First Party Appeal

Proposed Residential Development

Chrysanthemum Cottage, Chapel Road, Greystones, County Wicklow.

Wicklow County Council Register Reference No: 25/61046

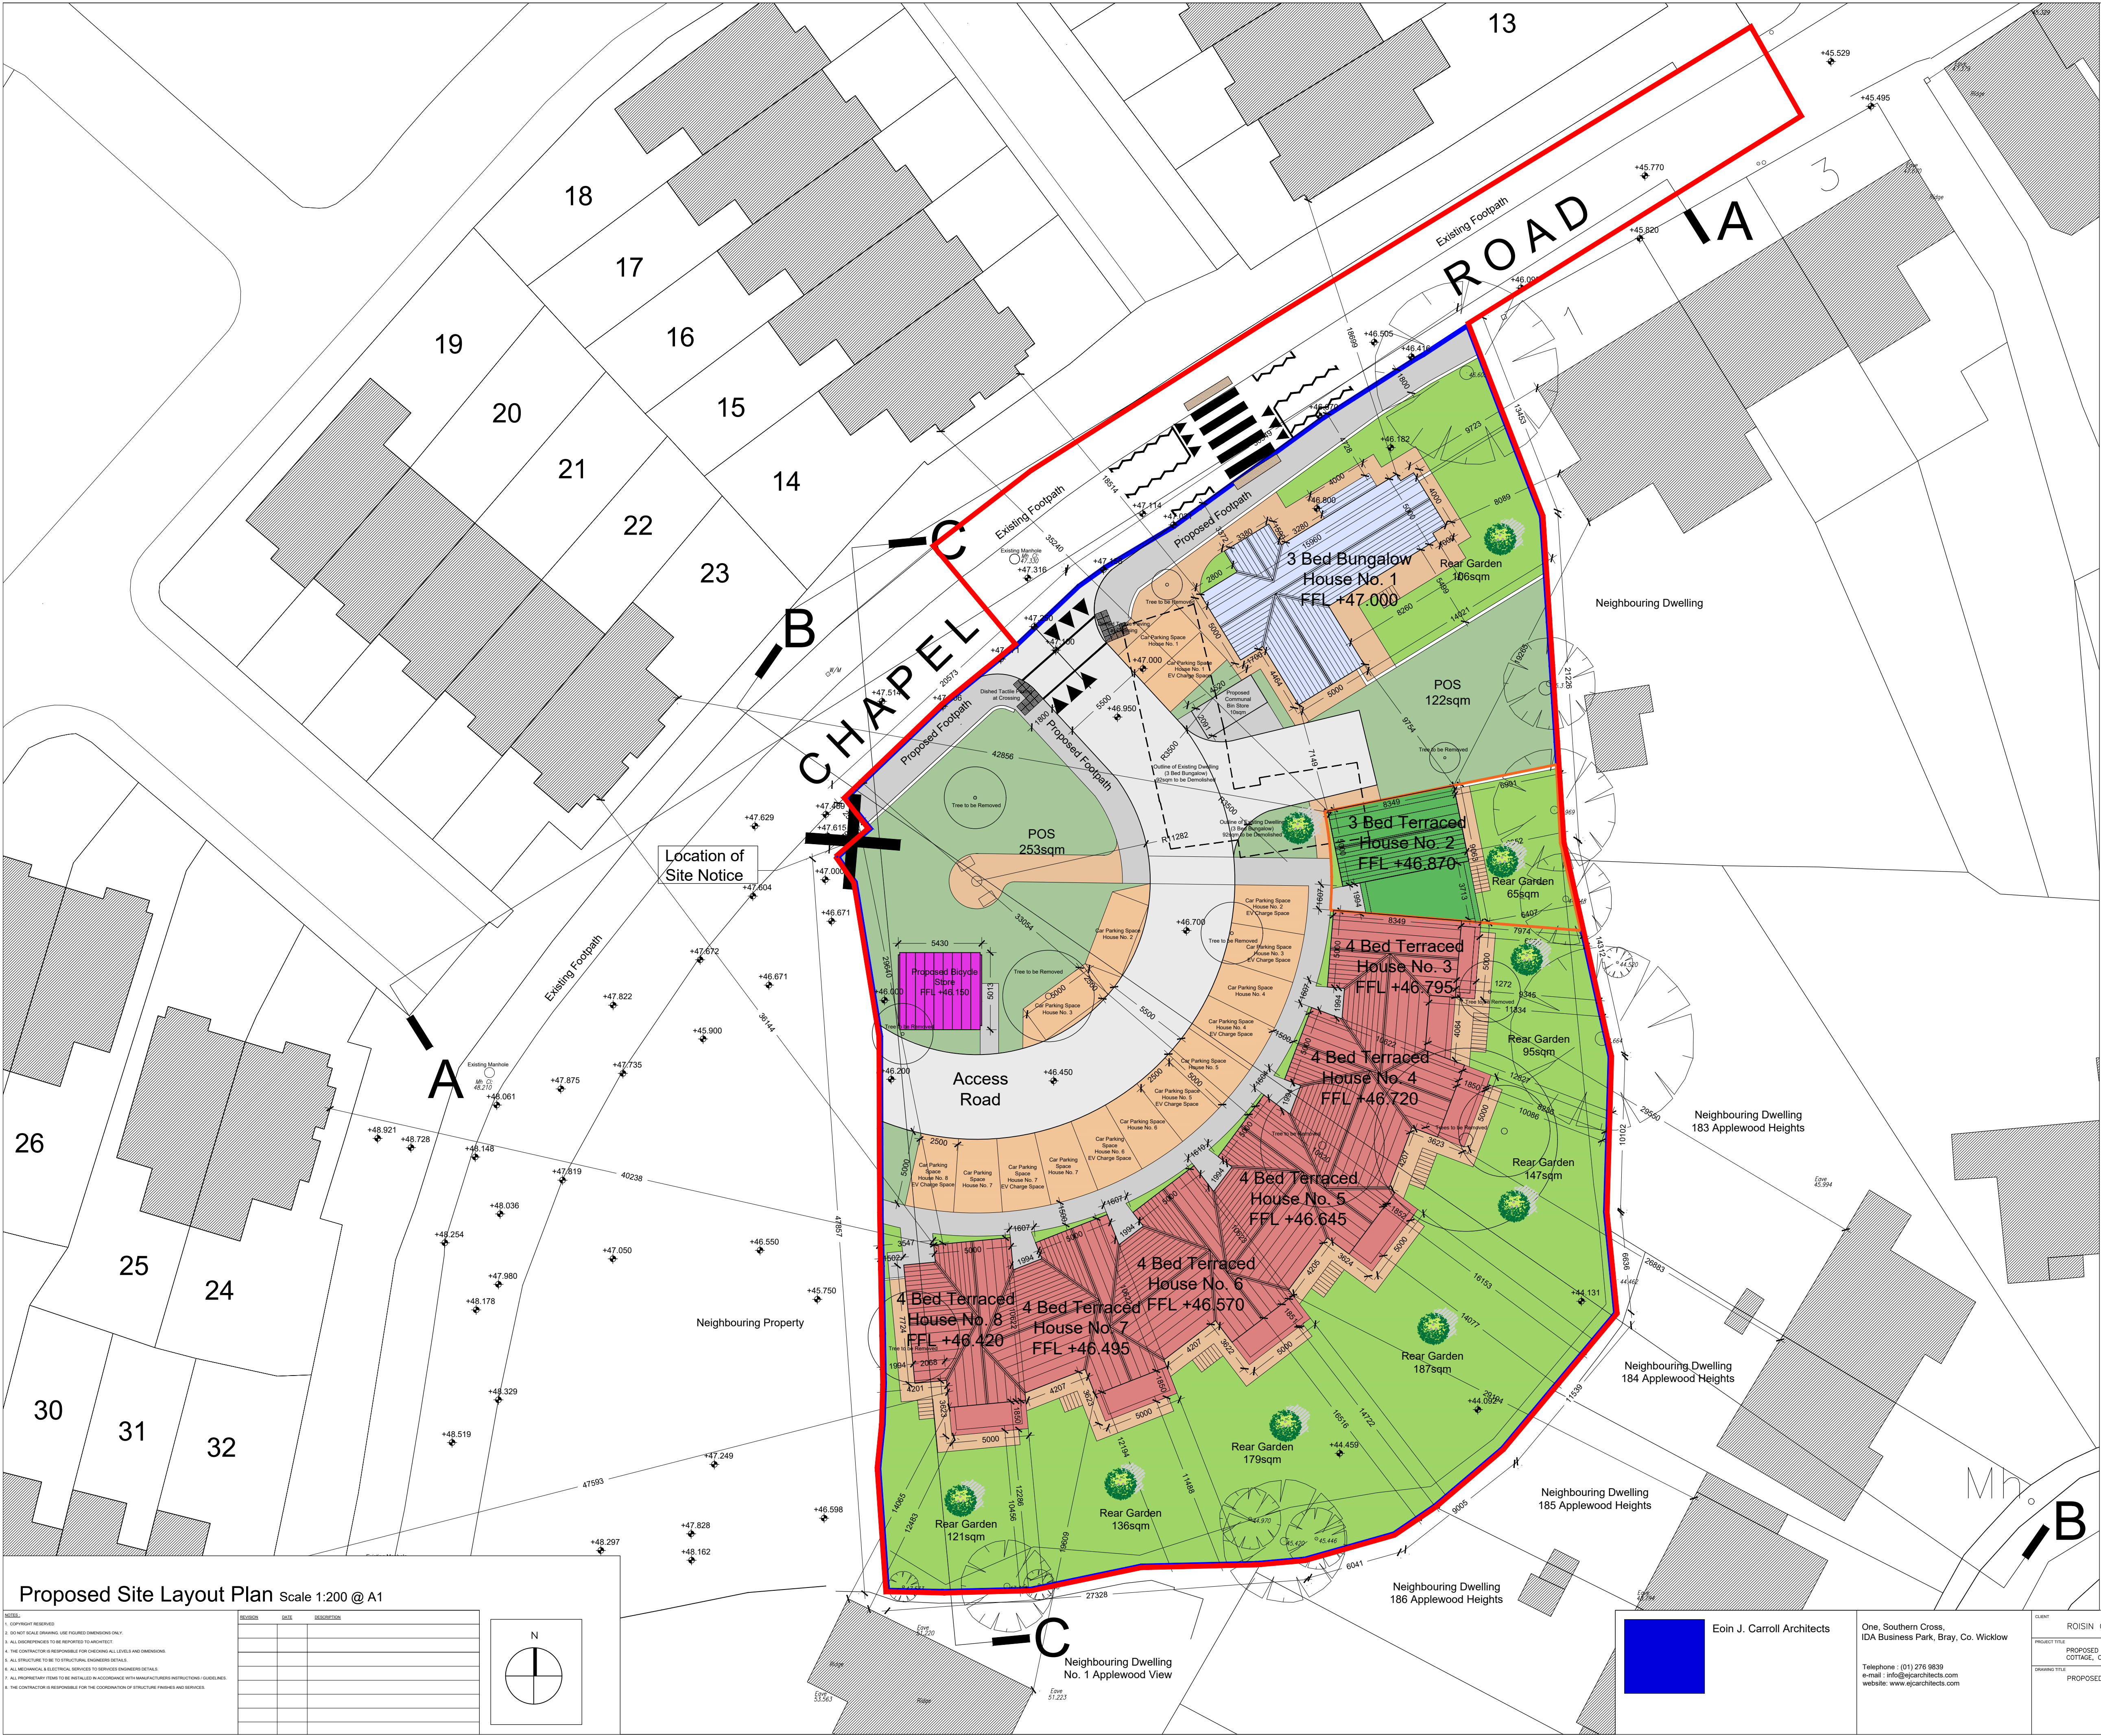
The allocation of car parking spaces is set out in the attached Site Layout Plan. The site layout plan has been amended and now also takes note of the Local Authority Planner's concerns regarding back to back perpendicular spaces and DMURS compliance. The two parking spaces on the public open space side of the access road are now proposed as parallel parking spaces to comply with DMURS.

Bicycle parking for the 5 mid-terrace dwellings will be provided by way of a communal secure bicycle parking area to the front of the terrace. This is now included on the revised Site Layout Plan and a detail drawing of the proposed bicycle parking proposal is submitted in support of this appeal.
